**FINAL PLAT
HARDY ROAD PROPERTIES
A PORTION OF THE SOUTHWEST QUARTER
SEC. 14, T11S, R65W OF THE 6TH P.M., COUNTY OF EL PASO, STATE OF COLORADO**

PCD Number: SF265

Project No.: 26009
February 23, 2026
Sheet 1 of 2

Project No.: 26009
April 18, 2026
Sheet 1 of 2

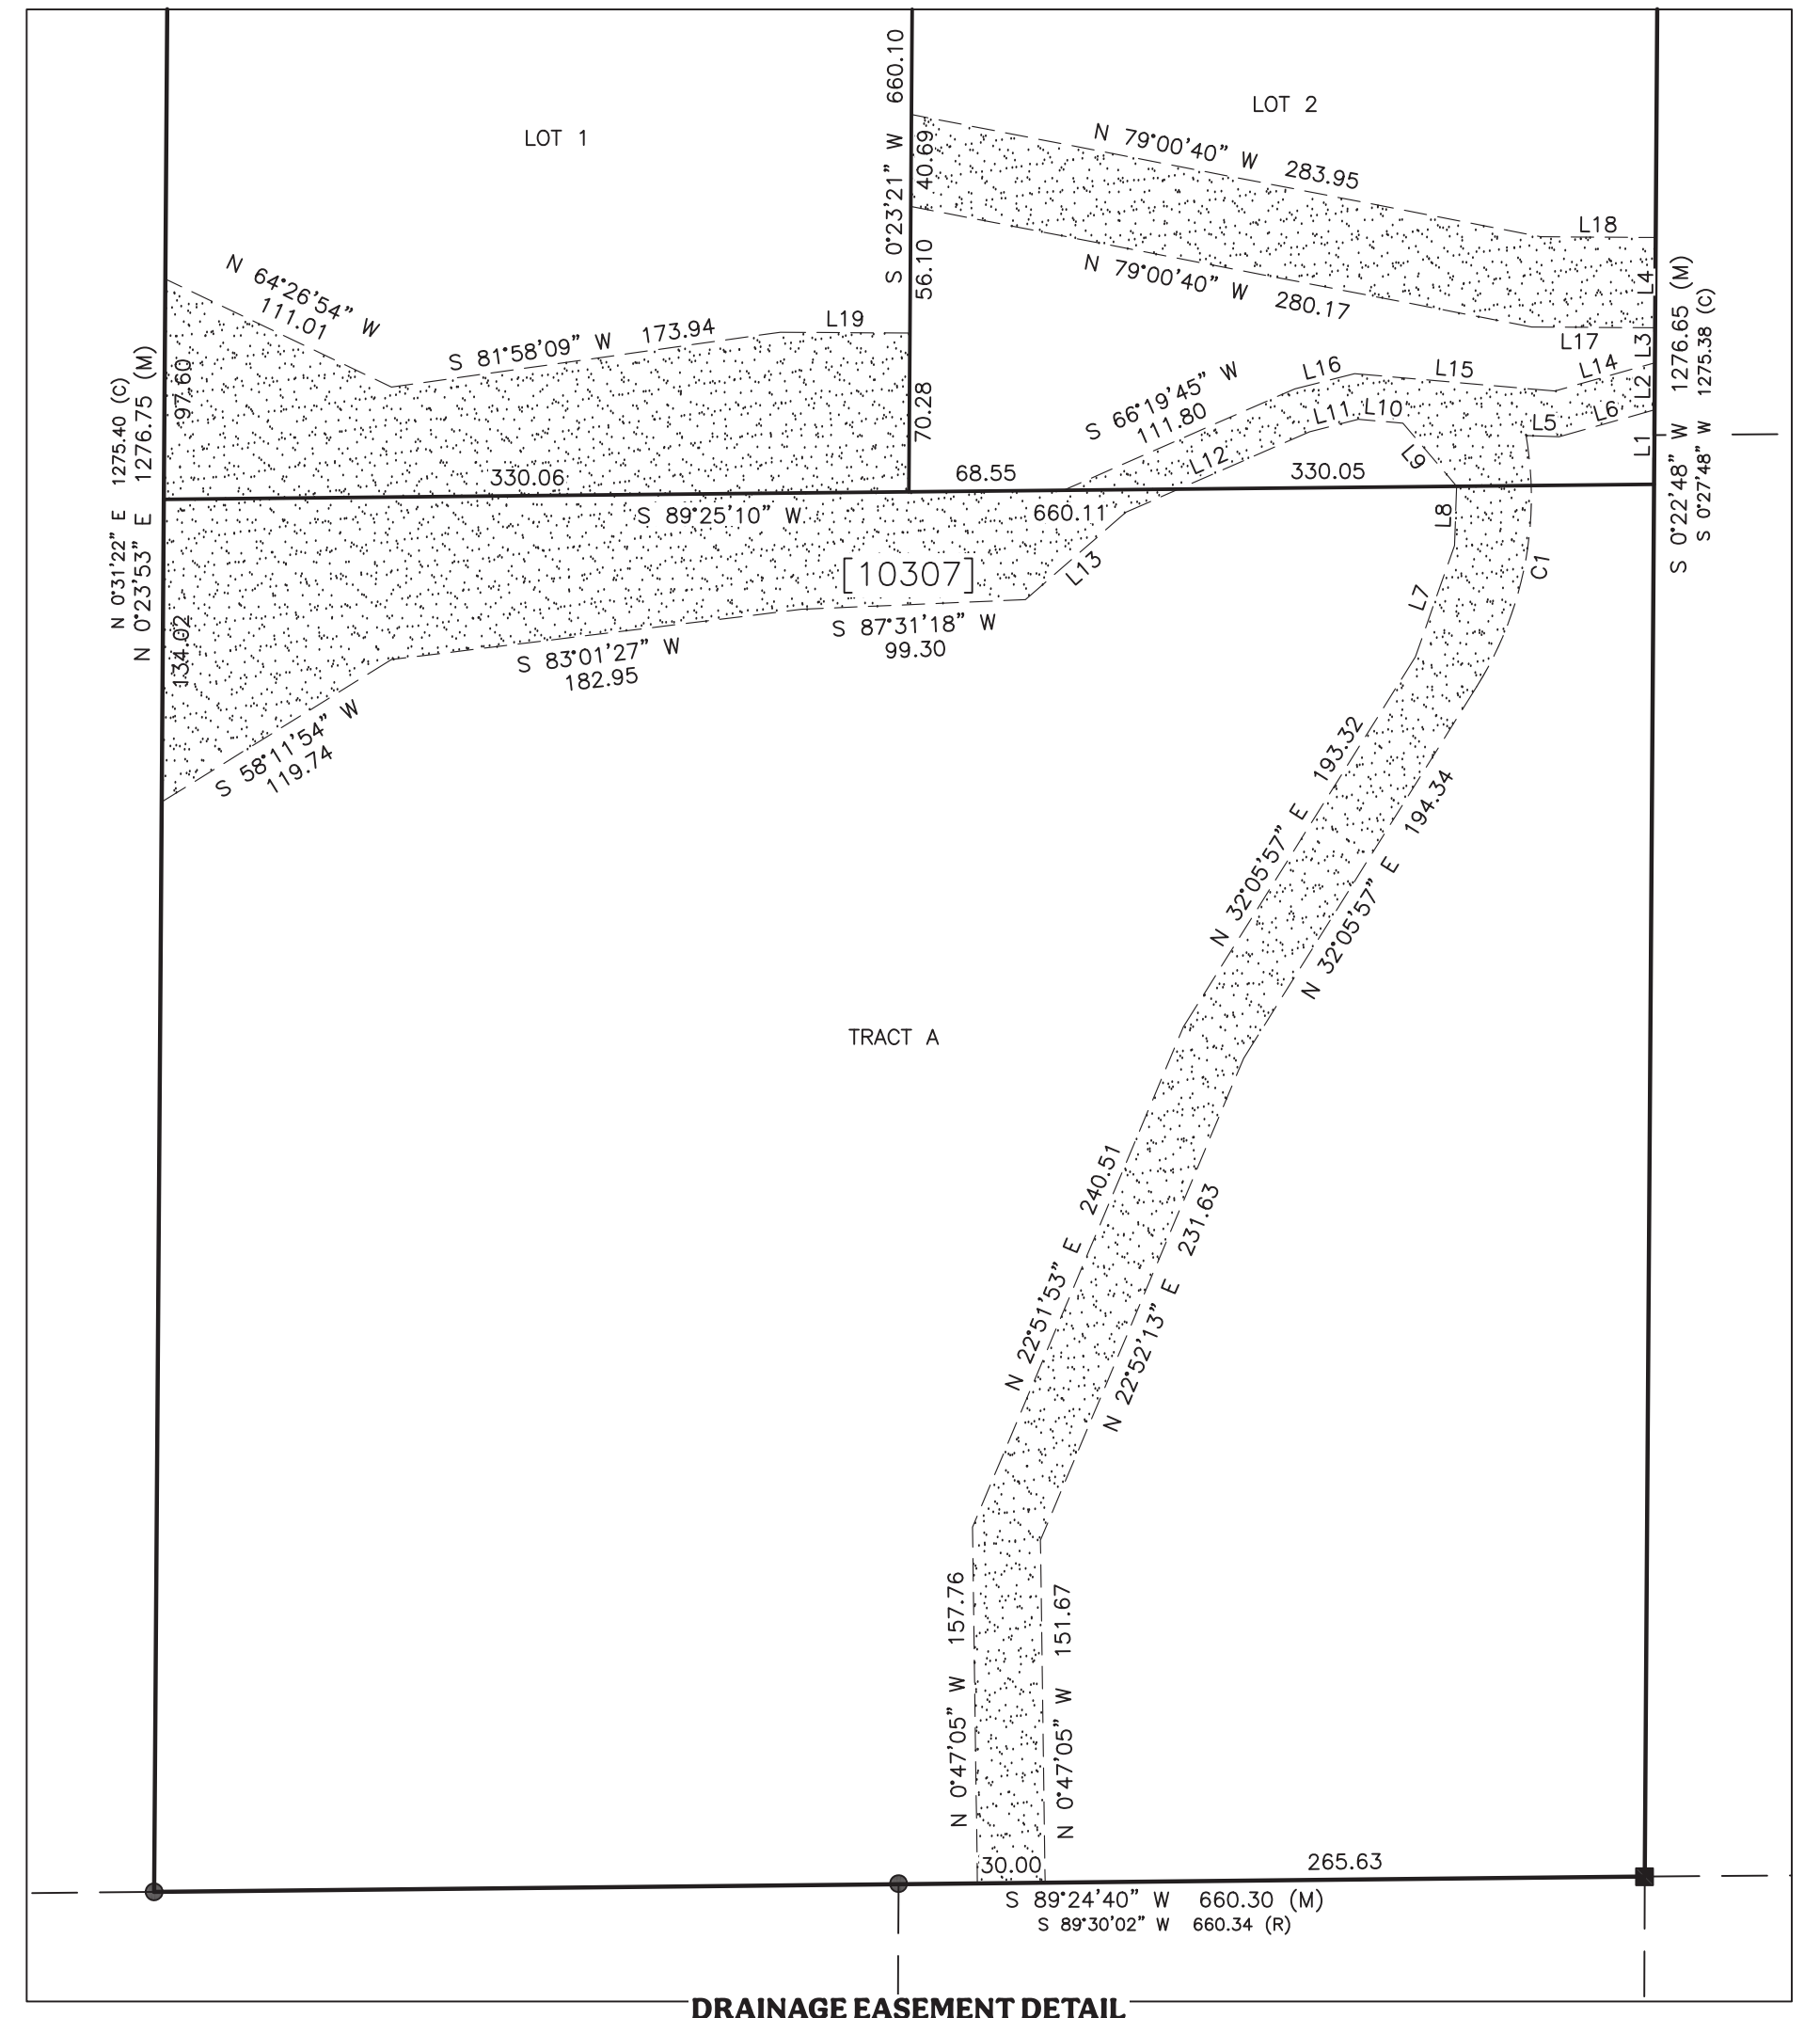
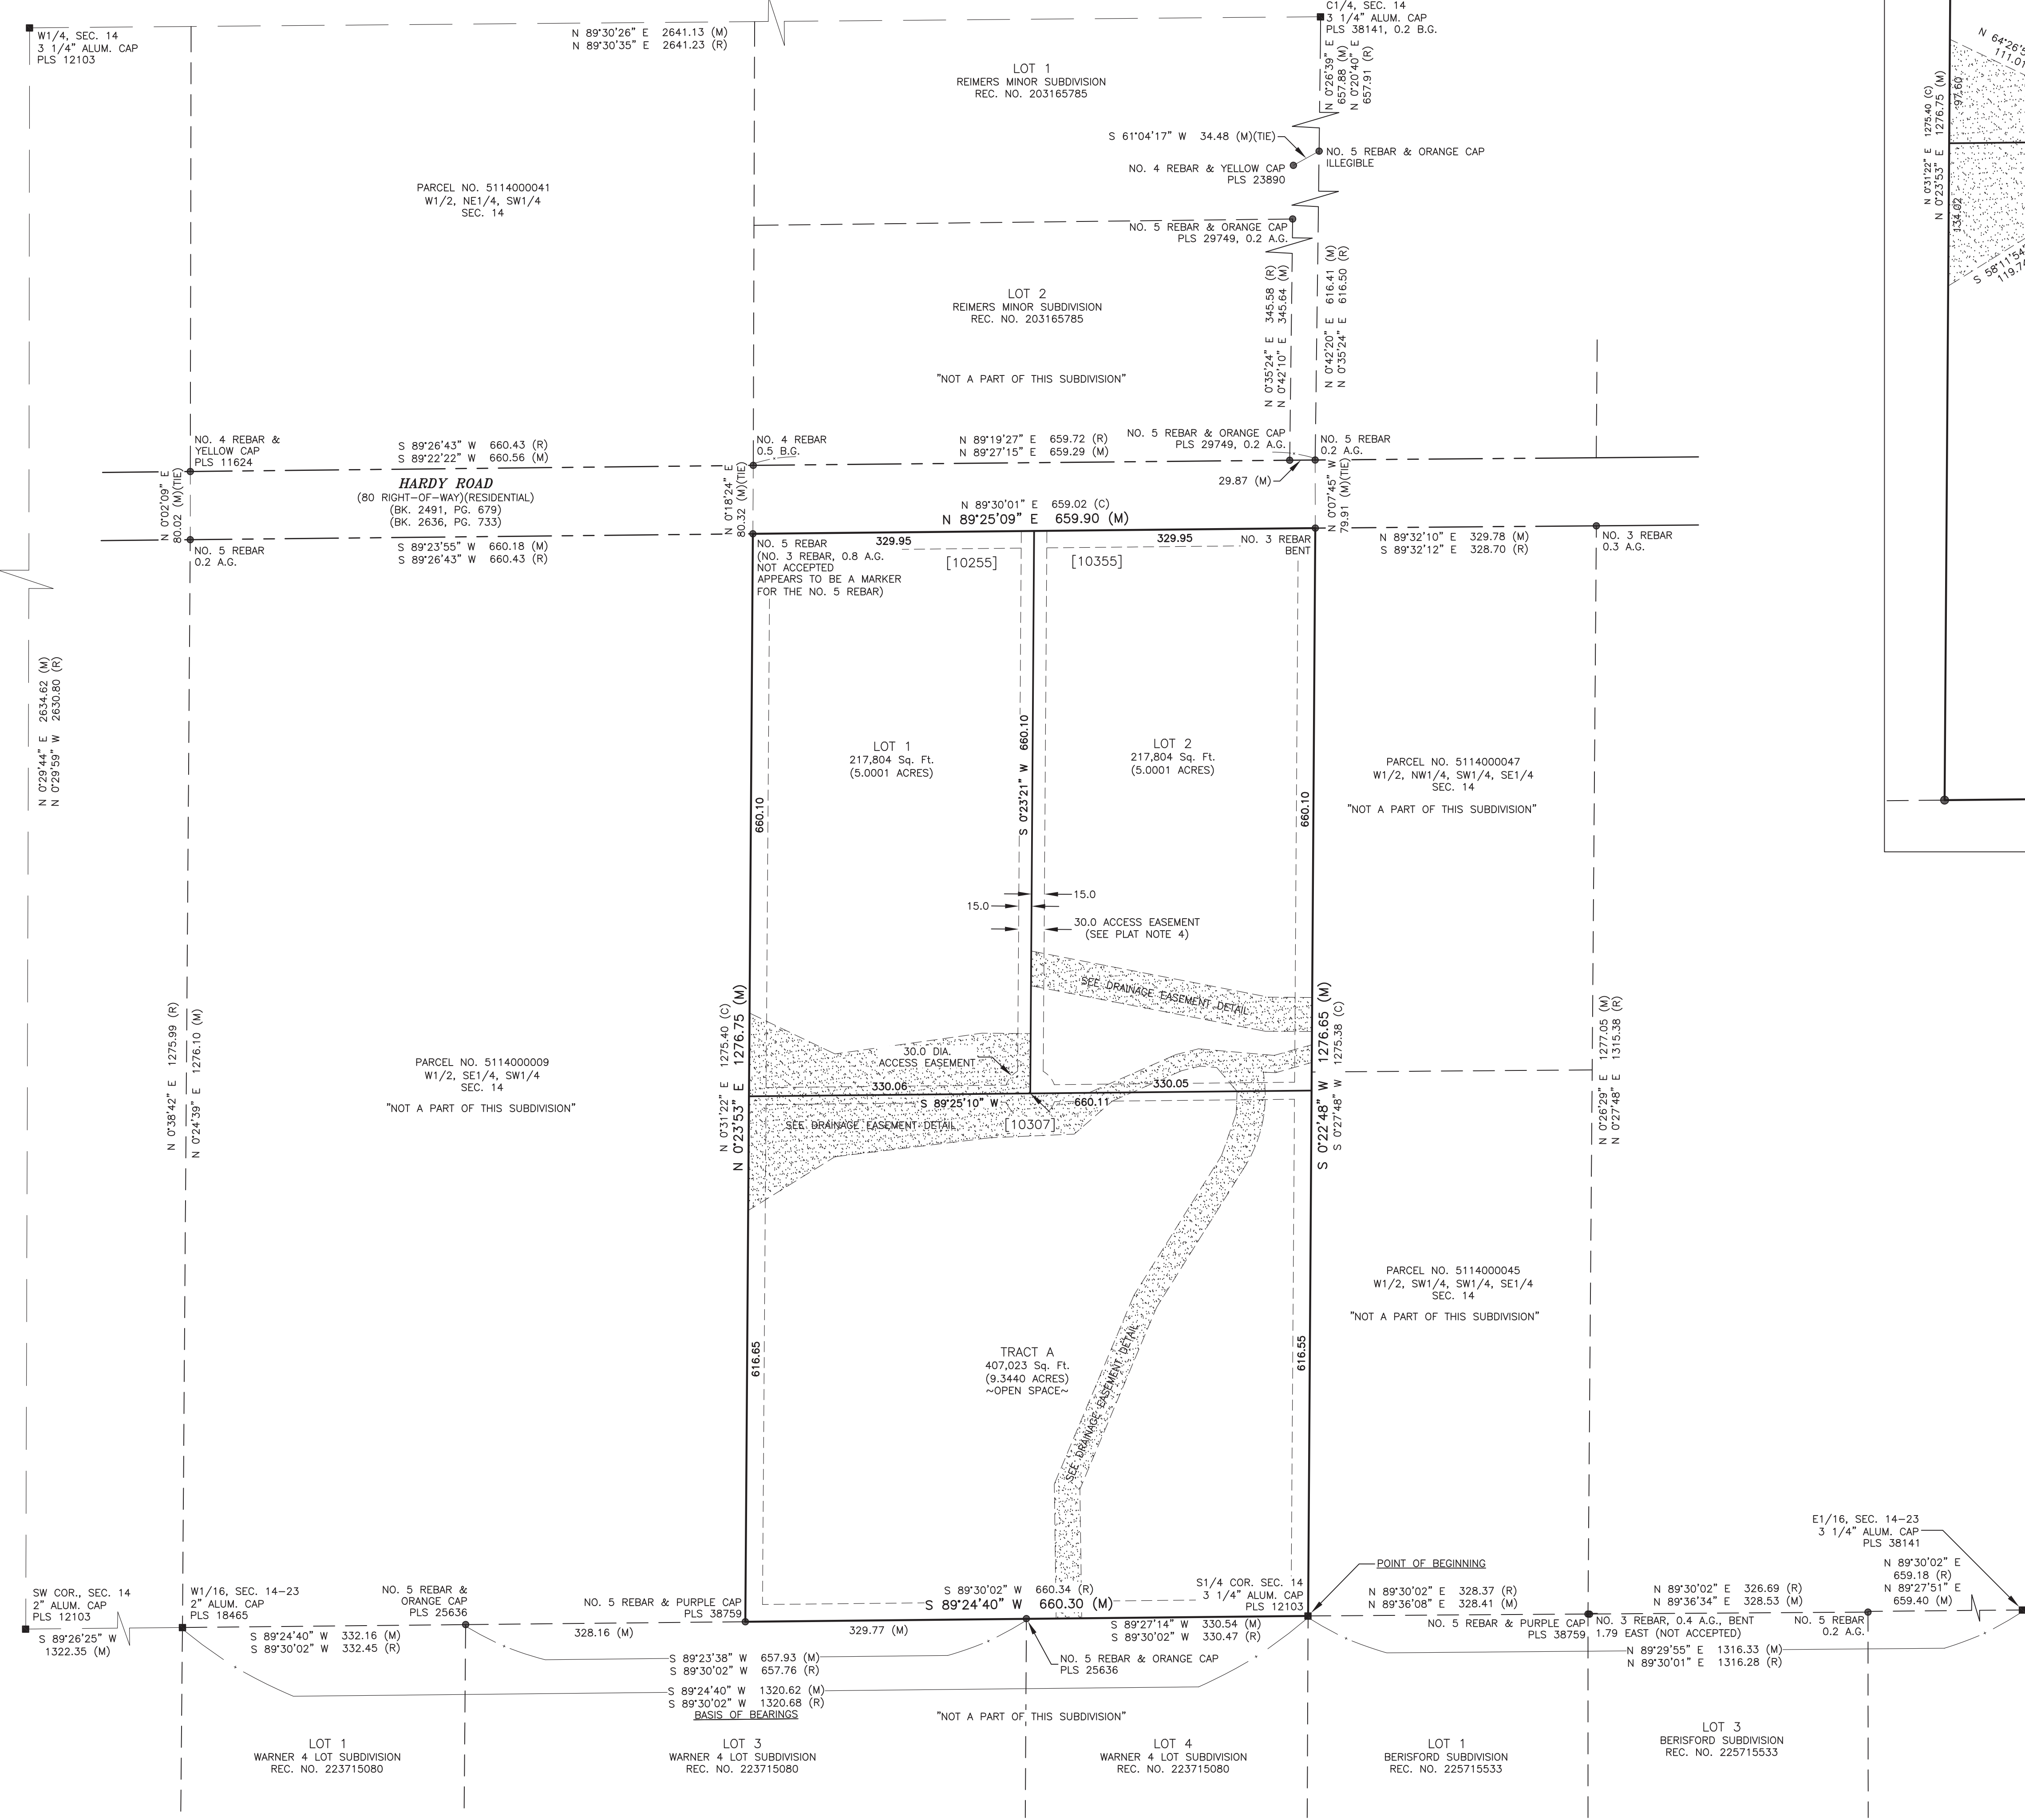
The two legals here do not match

Verify no Mortgage signature block is required

Possibly add note re: individual sub-surface soil test before construction, per soils report

Possibly add note re: water quality / corrosion potential for construction, per water report

Add addresses

Replace with " There are 3 lots and no tracts in this subdivision.

Add a note to the plat acknowledging that per ECM Section I.7.1.B.5, the residential lots impervious area may not exceed 10 percent unless a study is prepared in compliance with the requirements laid out in the above ECM Section and the impervious area may not exceed 20 percent. This impervious area for each lot must include the proposed driveway.

Add the following notes:

Please identify the use and ownership of Tract A (drainage, common area, non-buildable, etc)

Response: The legal on the plat is accurate

Response: There are not 3 lots

Response: PPRBD requires a site specific soils report with all building permits for foundations. The note would duplicate the PPRBD regulations and requirements in place today.

Response: Proposed note, but may be modified after EPC Health has provided comments.

Response: addresses will be added to page

Response: There are 2 lots

Response: note added
